Please attach these to the above application

Sarah Burrow
Engineering Assistant

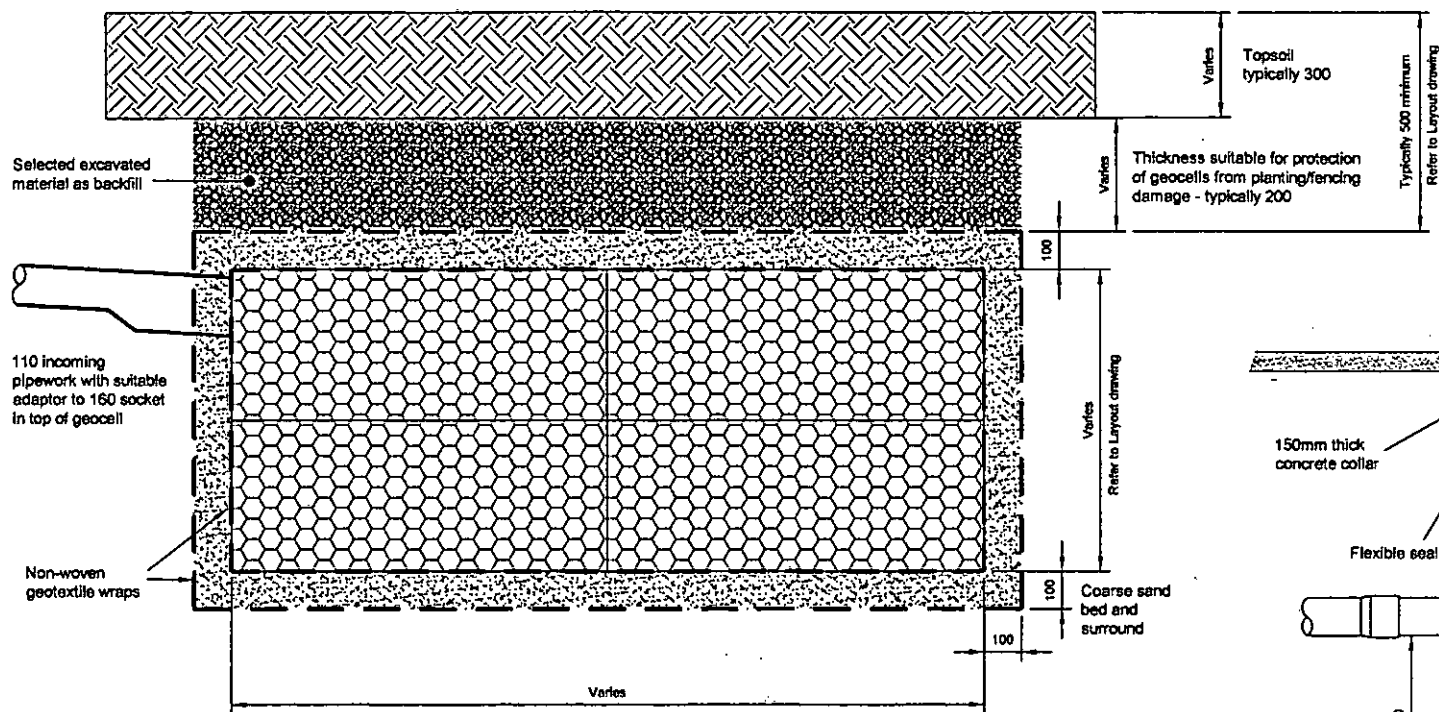
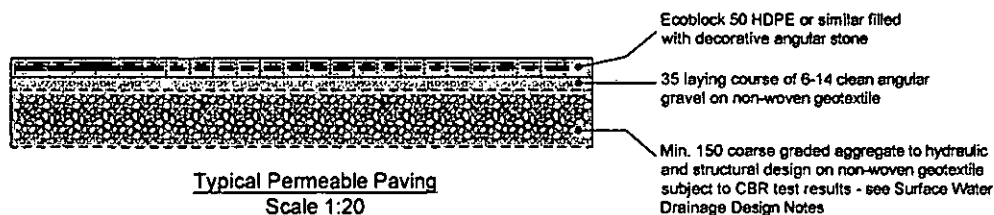
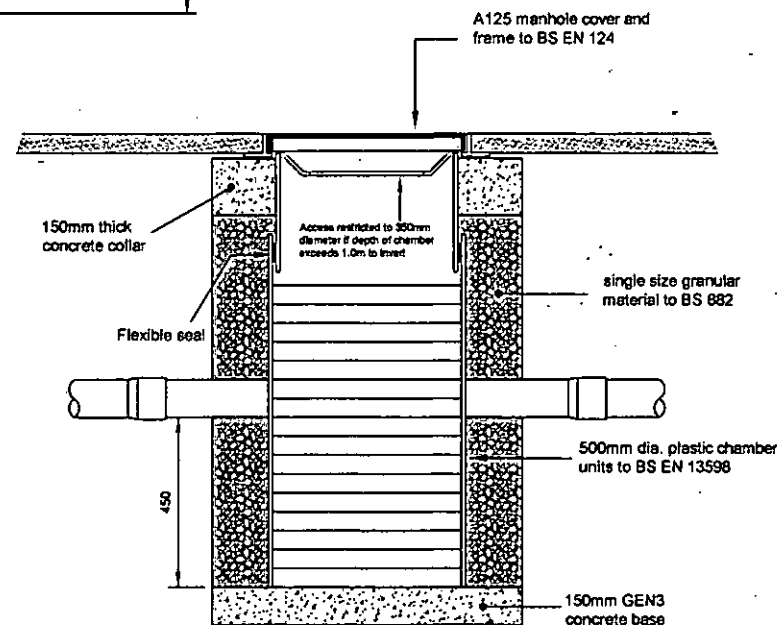
If you upload the amended plan with the details above, plus the updated construction details including pipe bed and surround then it should be ok.

Scale	As shown	A1 original	A3
Drawing Number	1795/SK1	Revision	-

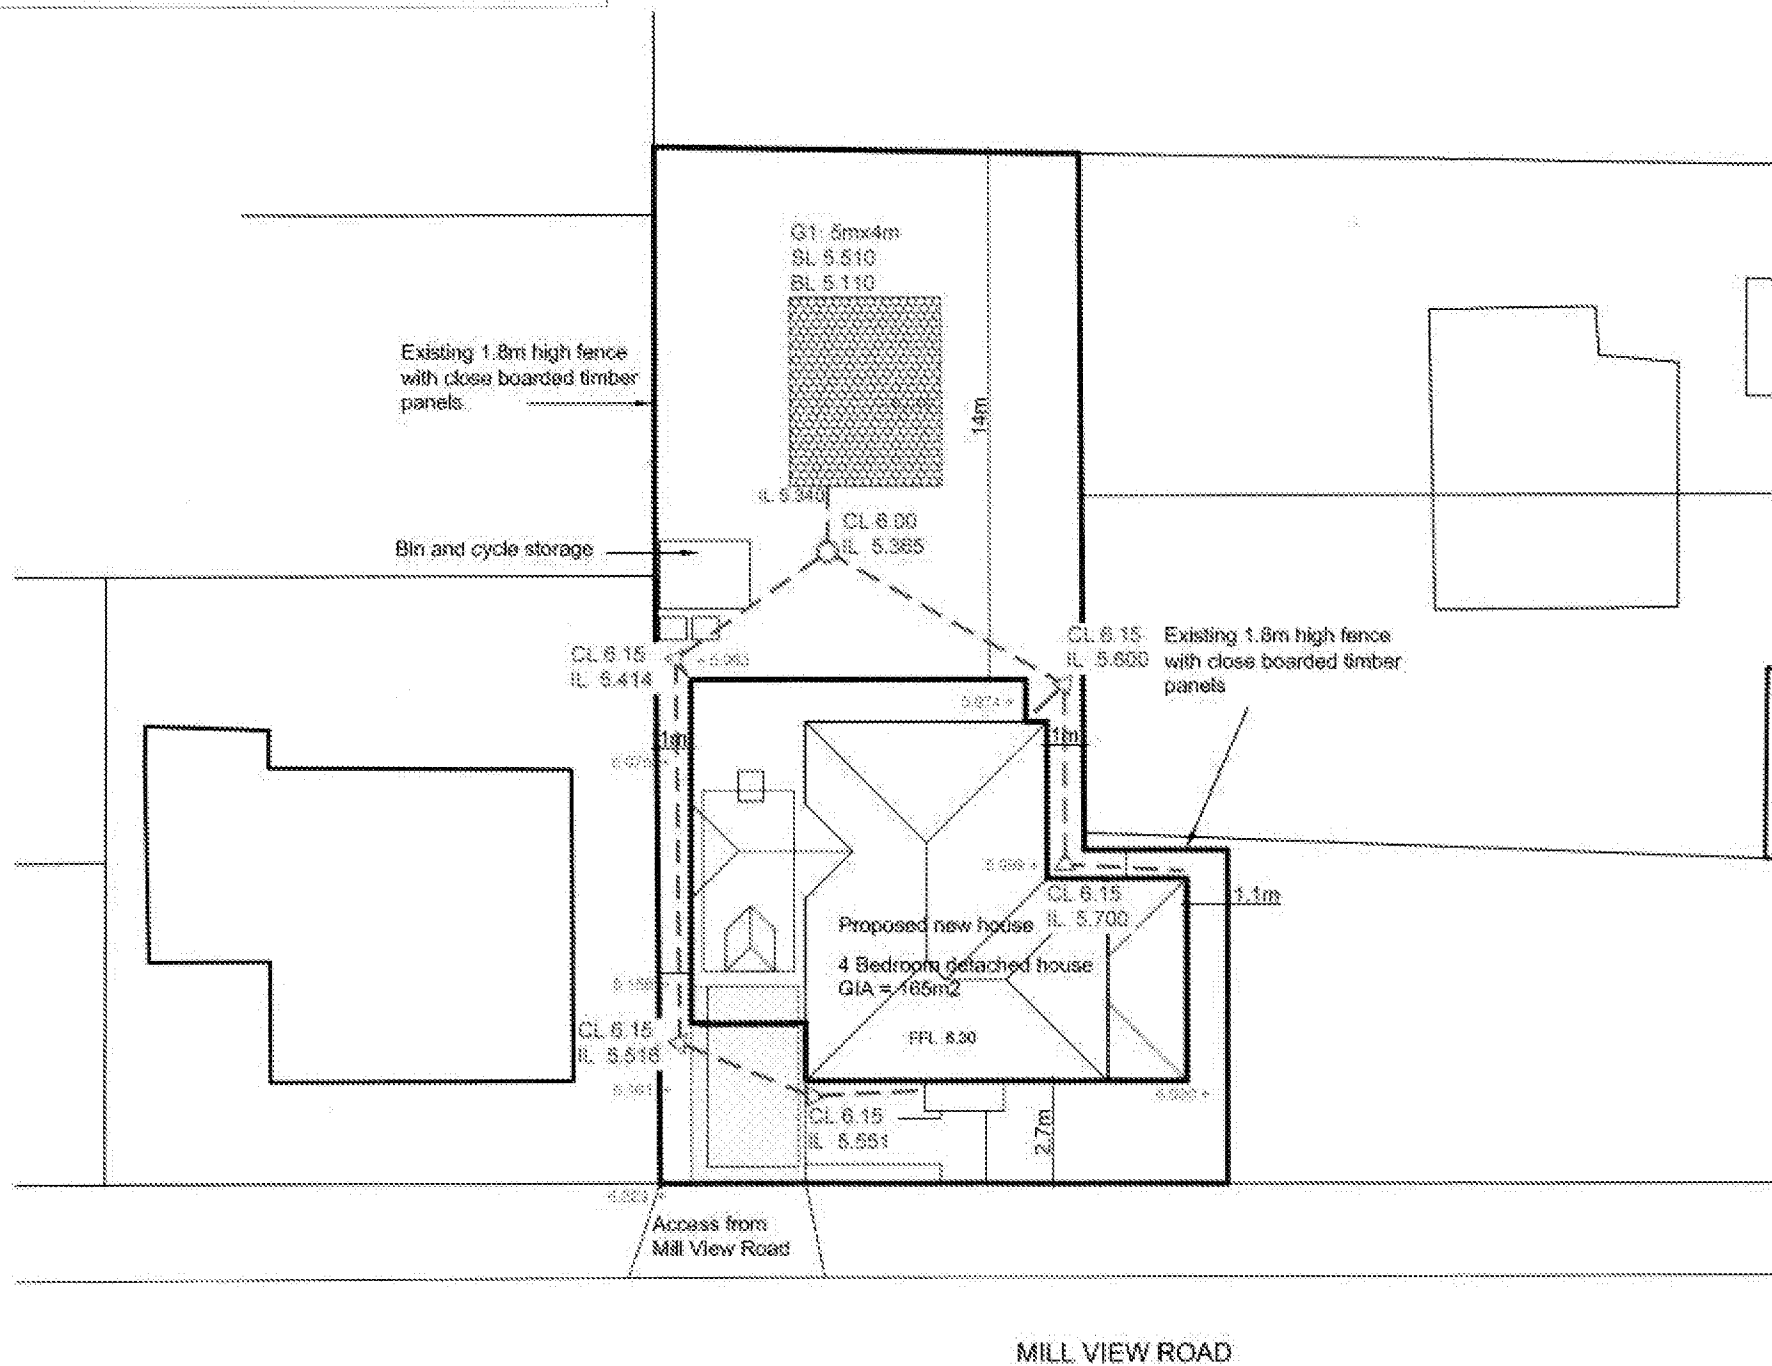
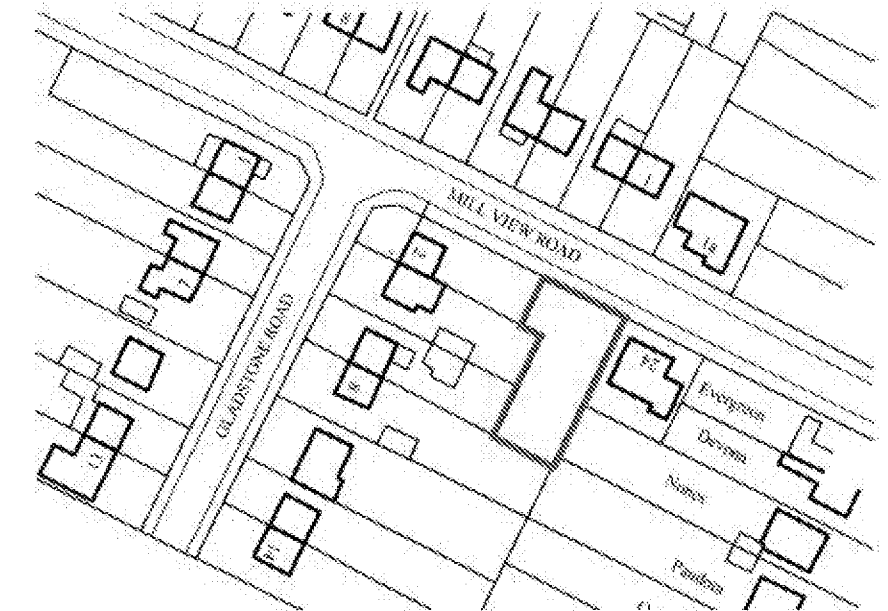
Therefore, whilst I understand most of what was said and agreed in that e-mail, what I am aiming for is a submission that covers the detail to avoid future questions. I would recommend including a line of text following your infiltration results on your plan, stating that this closely corresponds with the winter infiltration results obtained on application Y/38/17/HH for 14 Gladstone Road. (I note that the winter results were obtained in early November, I'm sure this was acceptable at the time but Paul has been quite firm with me that we did not accept infiltration results before December last year).

In addition I requested that you add a link for the borehole data that you referenced, this again can be on the plan. Simply "found at..."

GIA is fine, it was my misunderstanding. However it would be more helpful to have the impermeable area shown rather than the gross internal area for a drainage layout.
